Ribble Valley Borough Council  
Council Offices  
Church Walk,  
Clitheroe  
Lancashire  
BB7 2RA

Phone: 0300 123 6780  
Email: [Kathryn.Walsh@lancashire.gov.uk](mailto:Kathryn.Walsh@lancashire.gov.uk)  
Your ref: 3/2025/0006  
Our ref: 3/2025/0006/HDC/KW  
Date: 28 January 2025

**Location:** Avenue Farm Avenue Road Hurst Green BB7 9QB  
**Proposal:** Proposed demolition of existing dwelling, erection of replacement two-storey, four bedroom self-build dwelling with detached double garage and associated site works.  
**Grid Ref:** 368275 438410

Scale	Sheet Size	Drawing Status
1:100	A2	PLANNING
Job Number	Drawn By	Checked
24-016	AW	AW
Drawing Number	Revision	First Issue
PL06	F

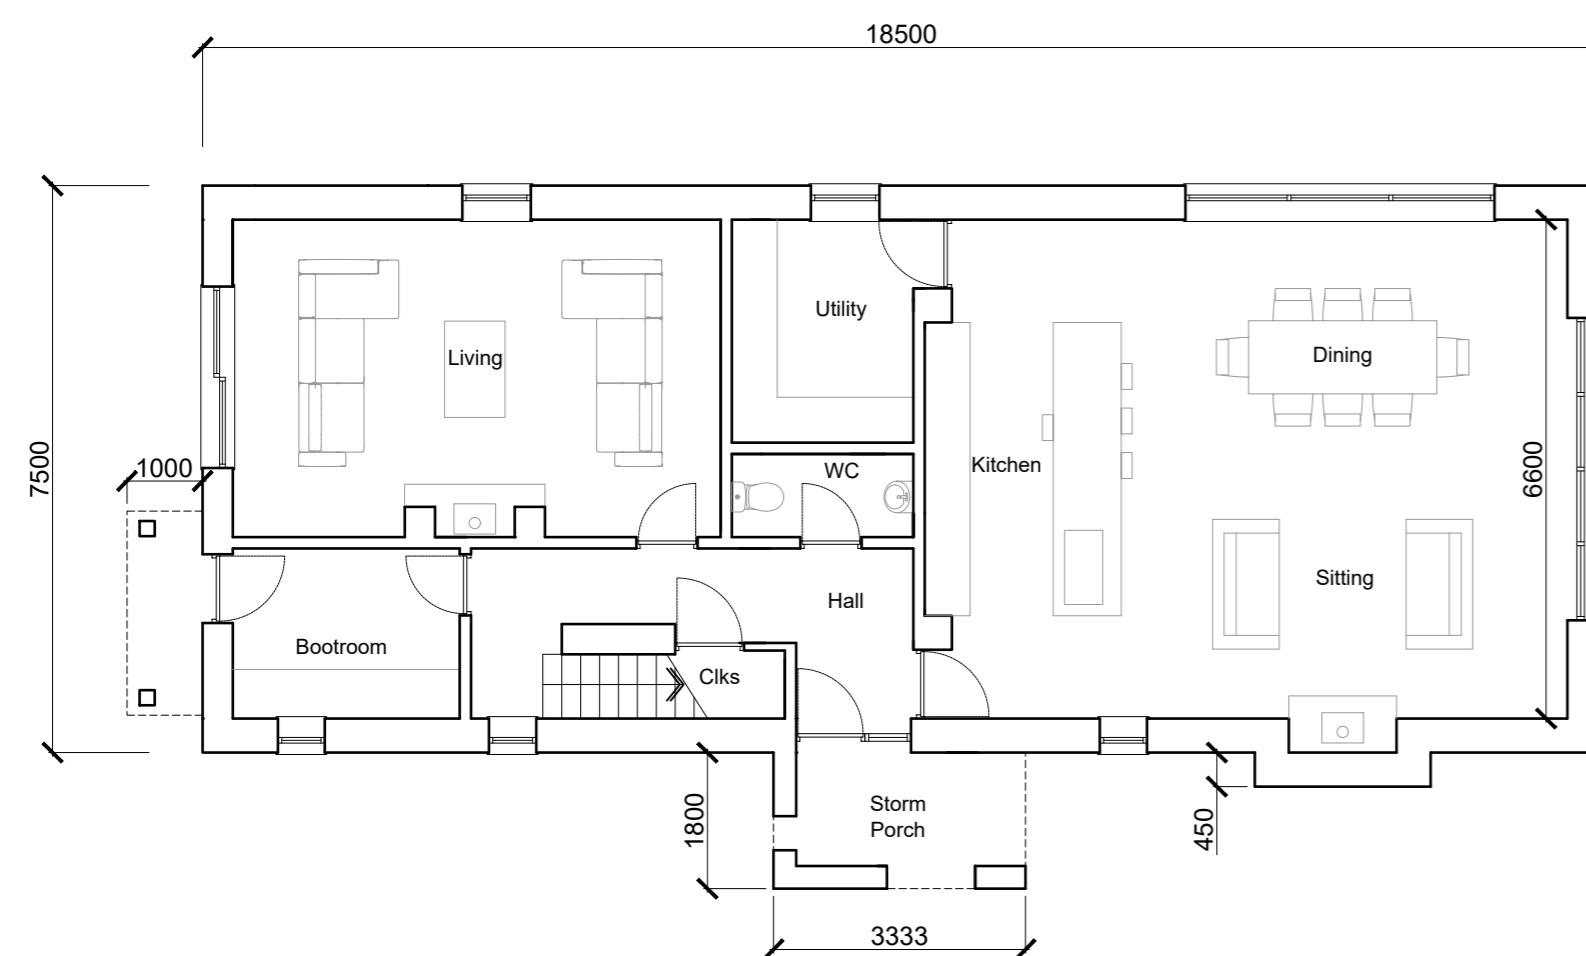
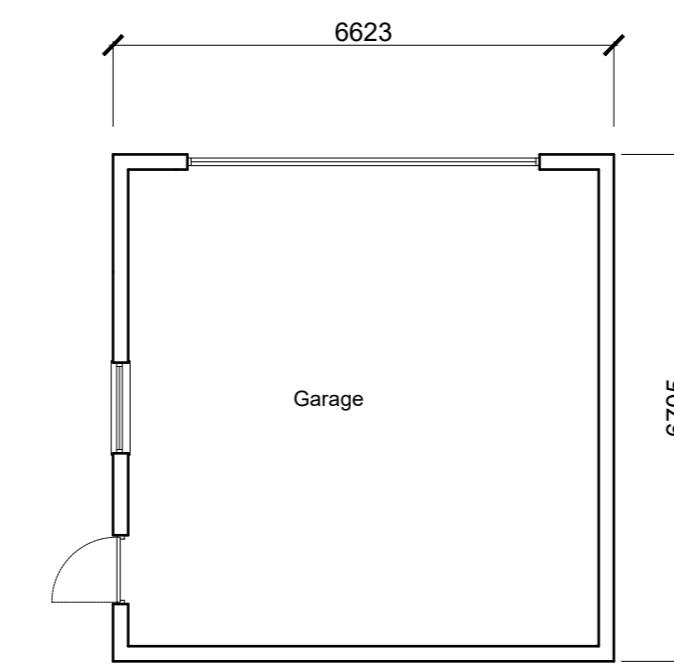
The LHA has reviewed drawing number 24-016 PL05 Rev C titled Proposed Site Plan and the proposed floor plan drawing 24-016 PL06 Rev E, and the LHA note that the proposed dwelling complies with the LHAs parking standards as defined in the Joint Lancashire Structure Plan.

The recommended minimum internal dimensions for a double garage size is 6m in length and 6m wide. As the garage meets the minimum internal dimension of 6m x 6m it can be counted as a parking provisions. Secure cover cycle storage can also be provided within the garage.
